RE: SUBMISSION TO SSD-78669234, Residential flat building with in-fill affordable housing
Address: 27-29 Tryon Road, Lindfield

ATTACHMENT 1

Ku-ring-gai Council's objection to SSD-78669234, Residential flat building with in-fill affordable housing at 27-29 Tryon Road, Lindfield

Figure 14 Proposed Level 4-6 Plan showing setbacks (Source: PTW)

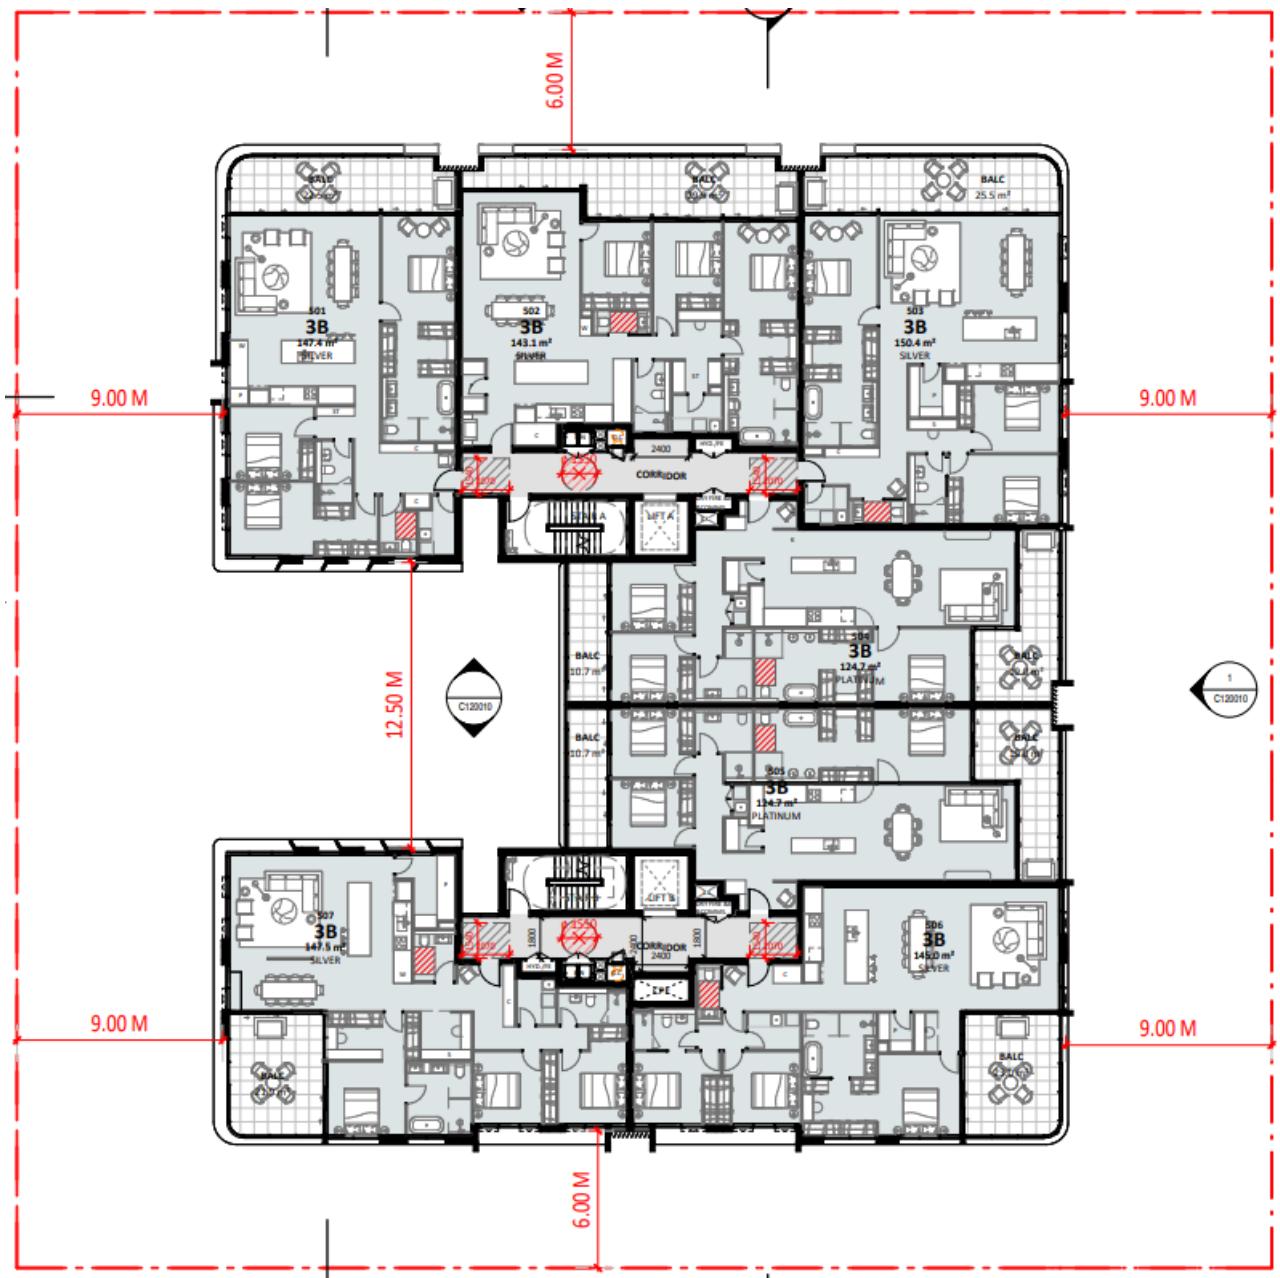
Side and rear setbacks should comply with the requirements of the ADG.

The proposal has many windows to habitable rooms and balconies with a building separation of only 3m from the western boundary from Ground Floor to Level 7 [DA-C120010 and DA-B1GRD10D to DA-B1L0710D]. This does not meet the requirements of ADG 3F-1 1 for a minimum building separation to the boundary of 6m for the first four storeys and a minimum of 9m for storeys five to eight. The proposal has windows to habitable rooms with a building separation of 6m from the western boundary at Level 8 [DA-C120010 and DA-B1L0810D]. This does not meet the requirements of ADG 3F-1 1 for a minimum building separation to the boundary of 12m for storeys nine and over.

The proposal is considered to significantly 'borrow' amenity from the neighbouring site to the west at No. 9-25 Tryon Road, will overlook its communal and private open spaces, and is not considered to share building separation distances equitably between neighbouring sites as required by the ADG. Compliance with minimum ADG requirements is not unreasonable and should be achieved. Increased setbacks would
